TO	Nicole Brewer, Director, Energy Assessments
FROM	Mark Davey
DATE	17 July 2026
OUR REFERENCE	0617753
SUBJECT	Keri Keri Wind Farm (SSD-3858962) Request for Additional Information

Keri Keri Wind Farm (SSD-3858962)–Request for Additional Information

Ref No	Theme	Submission	Response	Where Addressed
TfNSW-01	Traffic (generation)	1. Preconstruction Minor Works for workers accommodation camp traffic assessment requirements. A complete assessment of the wind farms and workers' accommodation camp construction pre-construction minor works is required and is to include: - Assessment of traffic volumes and identification of the types of vehicles that will be used during this period, including the largest design vehicle. - Perform a swept path analysis for the largest heavy vehicle at the existing intersection, ensuring it can navigate within the current pavement. If the design vehicle cannot turn easily, implement necessary mitigation or temporary works. - Assess existing Safe Intersection Sight Distance (SISD) and propose measures to achieve compliance, - Identify AM/PM peak hour traffic volumes and proposed volumes during this time. Traffic volumes during the AM/PM peak hours are to be c

Keri Keri Wind Farm - OSOM Routes 2A/2B
KM Index 77.0: Sturt Highway / Murray Terrace, Euston
Strategic Concept Design

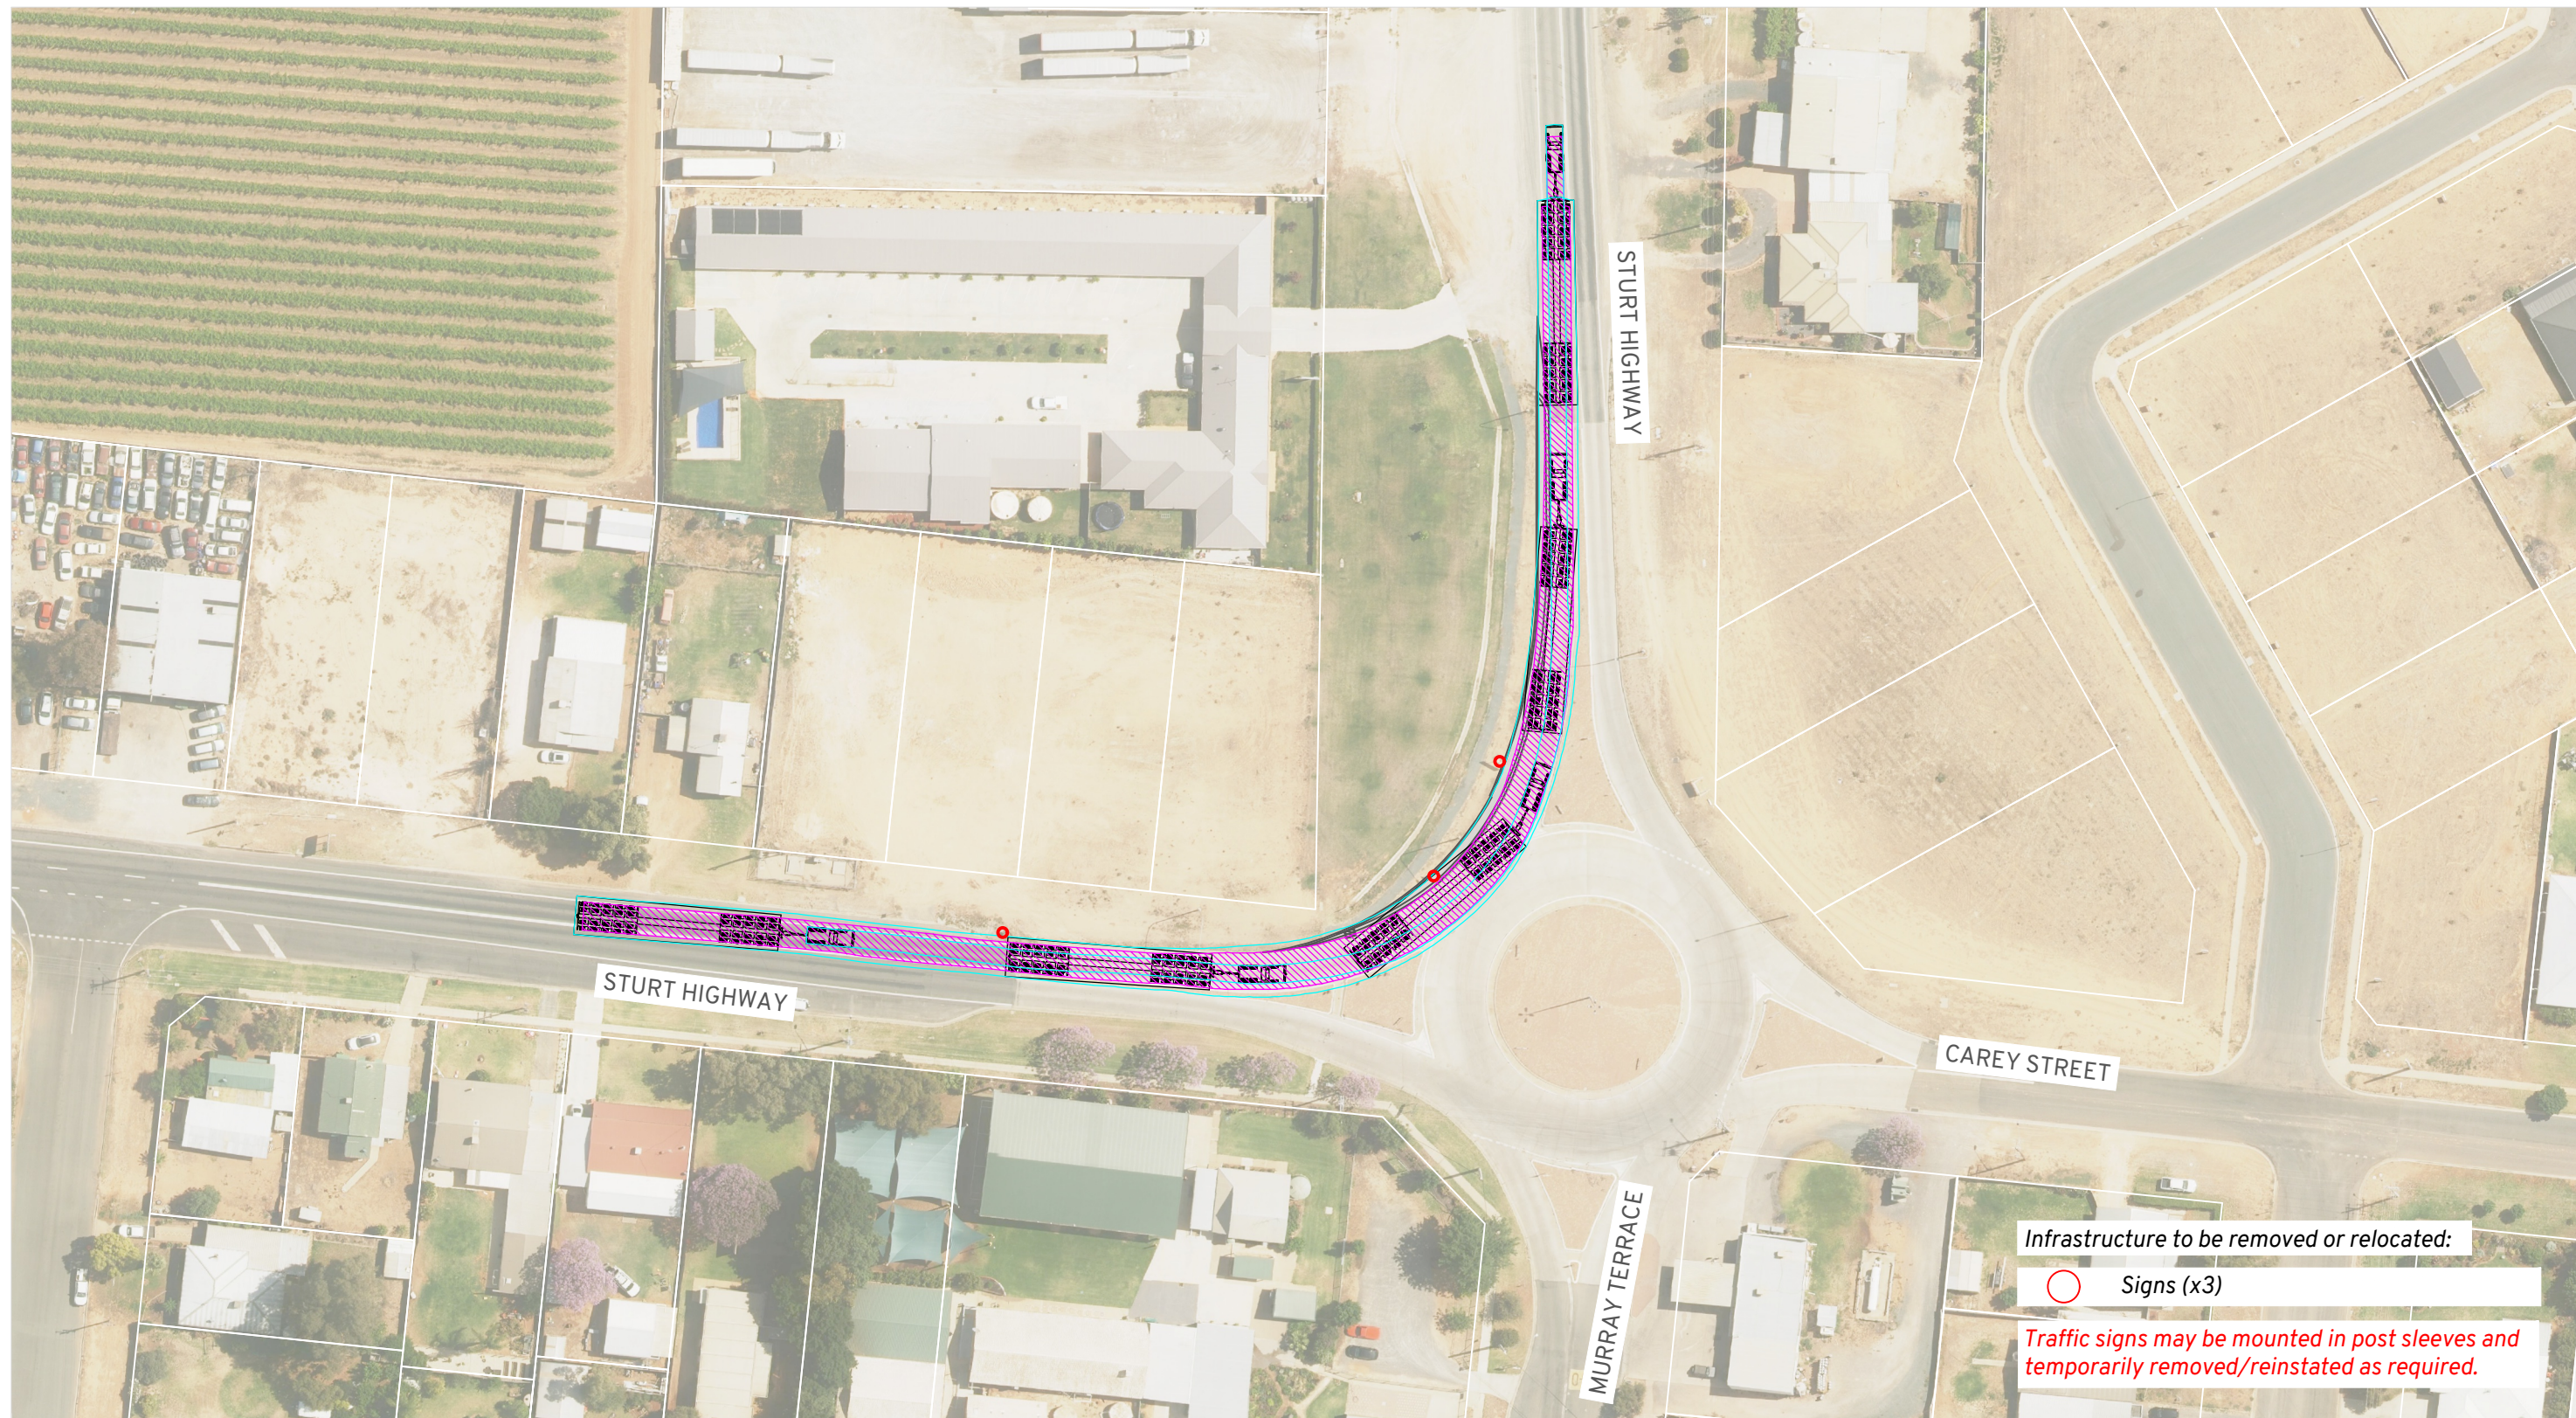
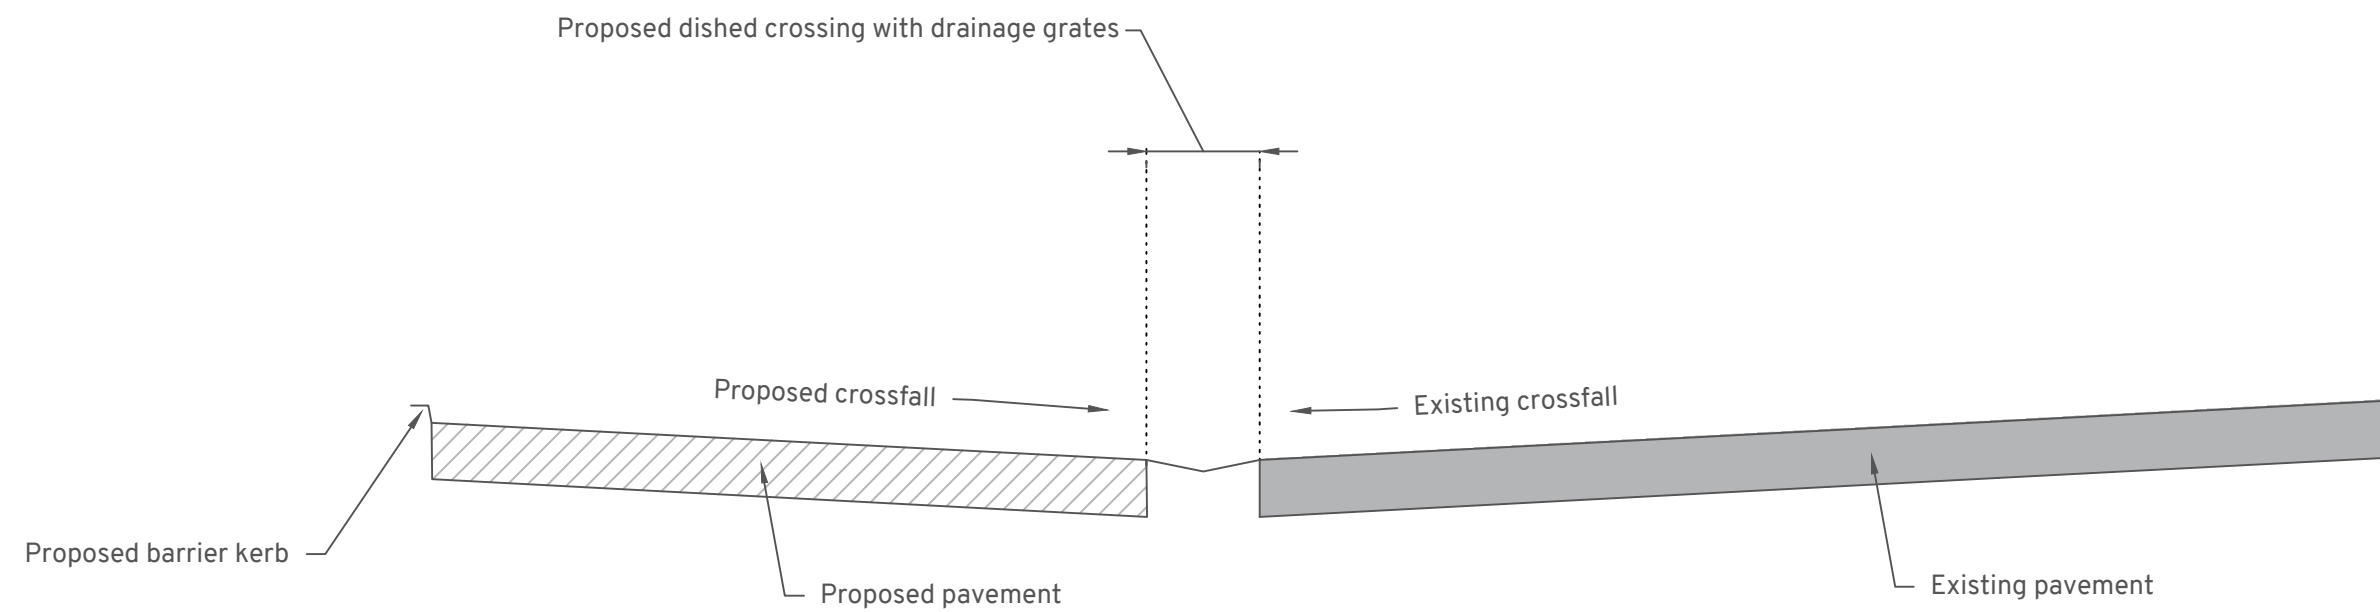
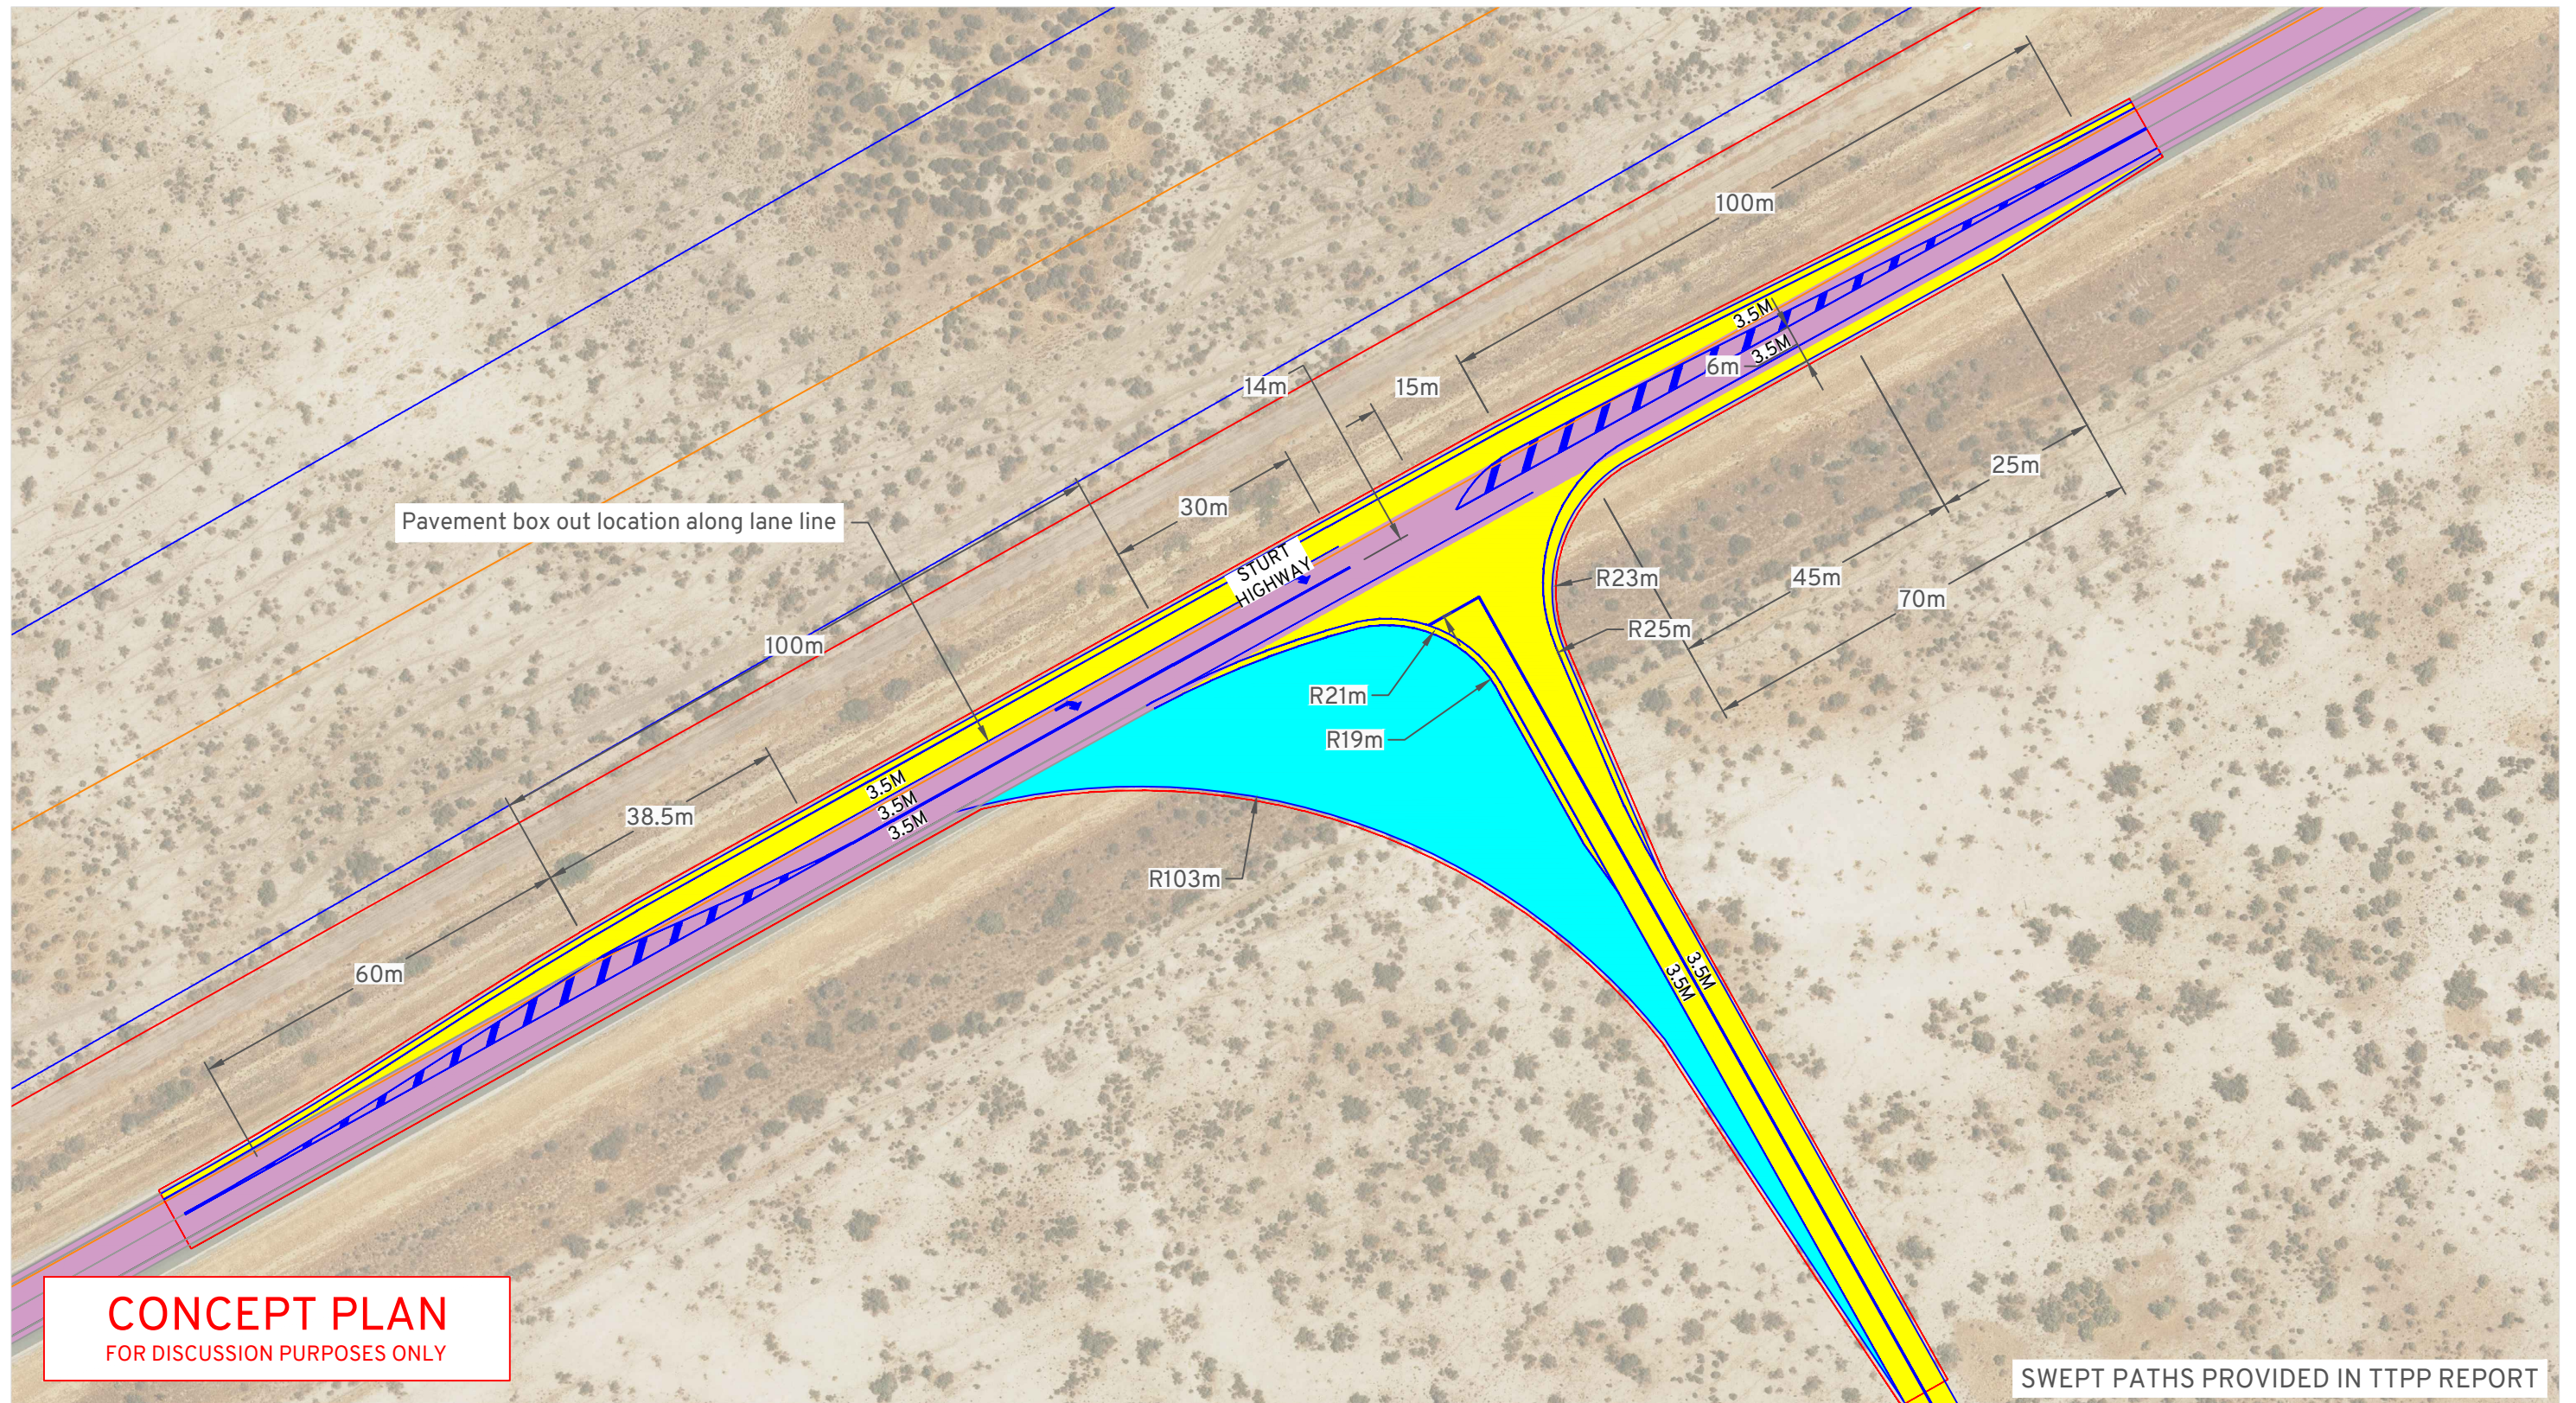
g. Revision D Civil Design RJ Andrews SPA - Sturt Highway at Euston - TfNSW requires a strategic concept hardstand design prior to determination, that includes the kerb replacement, existing drainage and other infrastructure checks that will impact on the scope of the road upgrades/modifications.	Strategic concept design for this intersection is provided in Appendix A (Sheets 08-10). The design includes a dished crossing with trafficable grates to facilitate movements onto the hardstand area.	Appendix A (sheets 08-10) of the Amended TIA (Attachment D)
